**WELWYN HATFIELD BOROUGH COUNCIL
DIRECTORATE OF STRATEGY AND DEVELOPMENT**

DELEGATED APPLICATION

Application No: 6/2016/0038/HOUSE
Location: 6B Hill Rise, Cuffley, Potters Bar, EN6 4EE
Proposal: Retention of detached garage, and alterations to roof to reduce the height.
Officer: Ms M Saunders

PROPOSED NORTH EAST ELEVATION

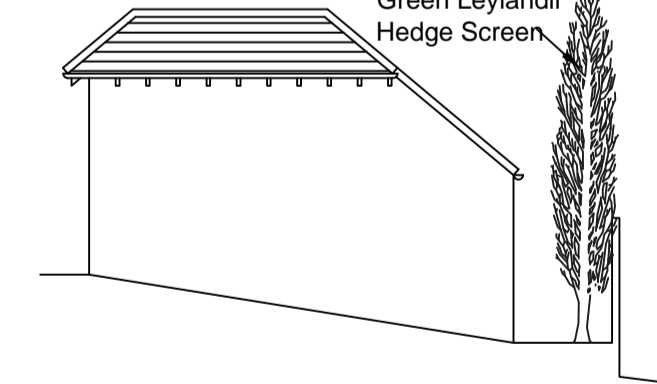
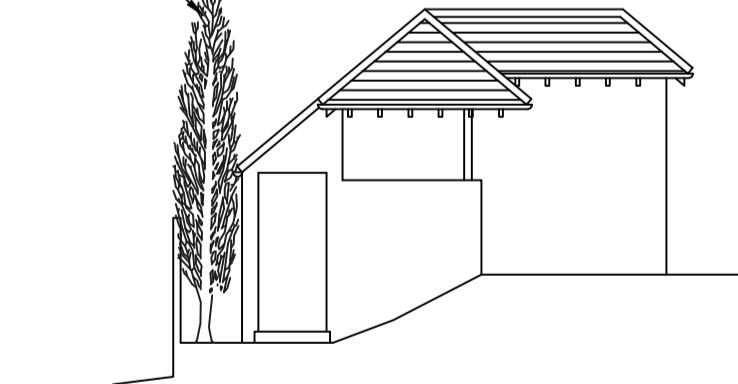
Revised plans have been received that proposes reducing the height of the building and altering the roof form. The ridge height would be reduced by approximately 1.9m and the roof form is considered less dominant. On the rear elevation, which would have the most impact on neighbours, the eaves height has been reduced by approximately 1.1m to 2.3m when measured from the application site.

It is proposed to remove the window within the existing north east elevation and to plant a hedge screen along the rear boundary of the site to reduce impact on neighbouring properties. In the event of an approval, a condition would be included that ensures the boundary treatment is maintained.

The revised scheme helps to overcome issues raised by neighbours in regards to the garage appearing overbearing and intrusive and in addition due to the reduction in height, the garage does not have the appearance of a two storey dwelling and would not create an unacceptable loss of light. The removal of the window on the rear elevation also removes the element of a loss of privacy.

PROPOSED FLOOR PLAN WITH SCREENING

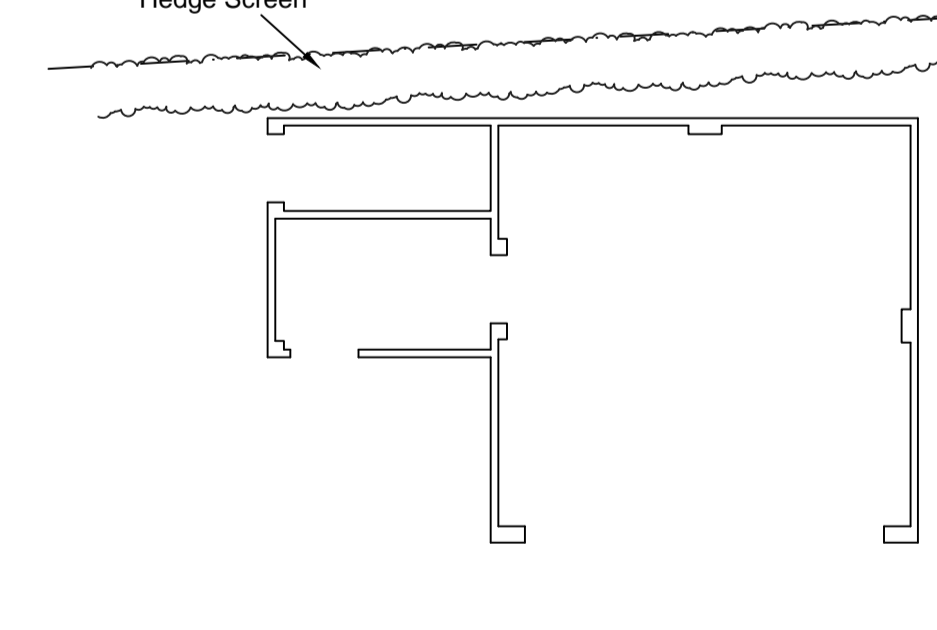
Taking into account the reduced roof height and the planting of the leylandii hedge screen, it is considered that the amenity of adjoining occupiers is maintained to an acceptable level and does not warrant the refusal of the application.

3. The hedge[s] marked on the attached plan numbered GVBS - 6B Hill Rise shall be retained unless the Local Planning Authority gives its written consent to its removal or variation. Should any part of the hedge die, be removed or become seriously damaged or diseased, it shall be replaced during the following planting season by a hedge planted in accordance with a specification previously approved in writing by the Local Planning Authority.
